LSC TRANSPORTATION CONSULTANTS, INC.
2504 East Pikes Peak Avenue, Suite 304
Colorado Springs, CO 80909
(719) 633-2868
FAX (719) 633-5430
E-mail: lsc@lsctrans.com
Website: <http://www.lsctrans.com>

D-49 Transportation Center
Traffic Impact Study
(LSC #S214340)
PCD File No. U-221
May 9, 2022

LSC Responses to TIS Redline Comments

Figure 2
Proposed Site and Access Plan

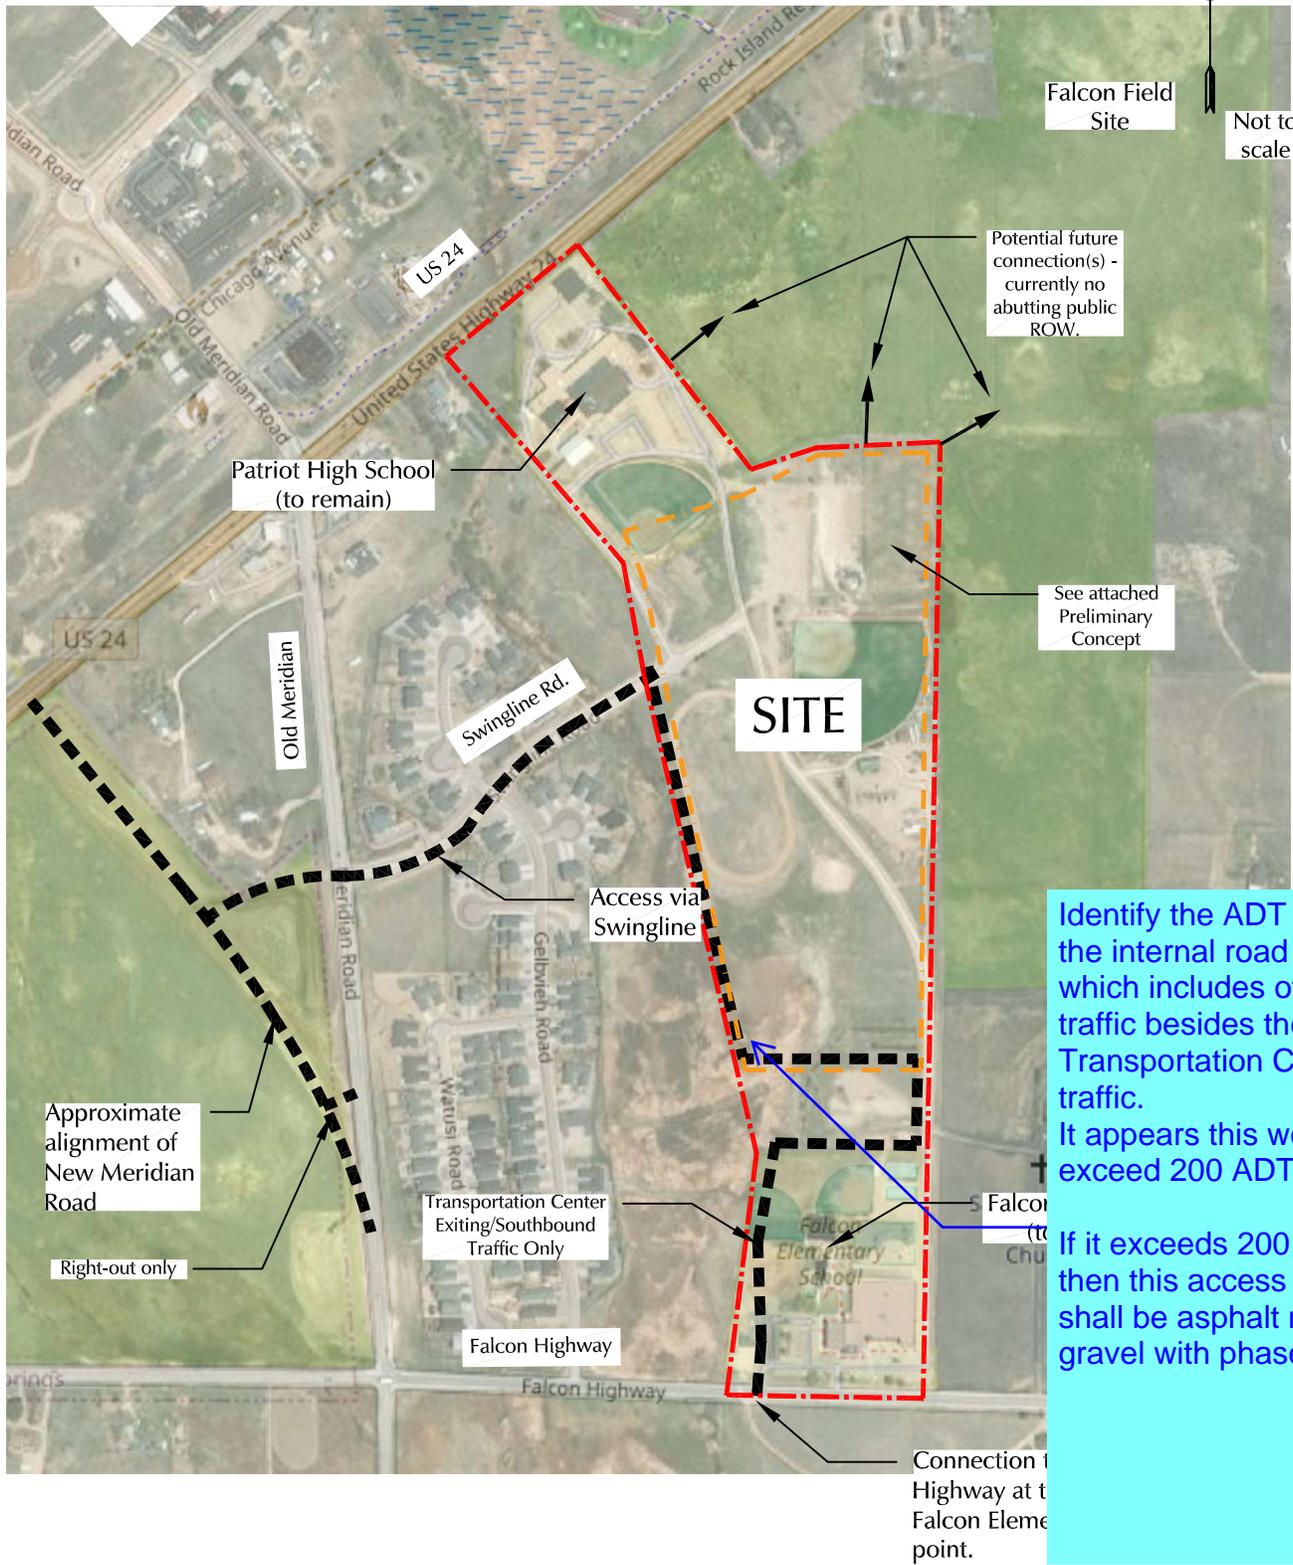
Identify the ADT of the internal road which includes other traffic besides the Transportation Center traffic. It appears this would exceed 200 ADT. If it exceeds 200 ADT then this access road shall be asphalt not gravel with phase 1.

LSC Response: The updated report addresses this comment.
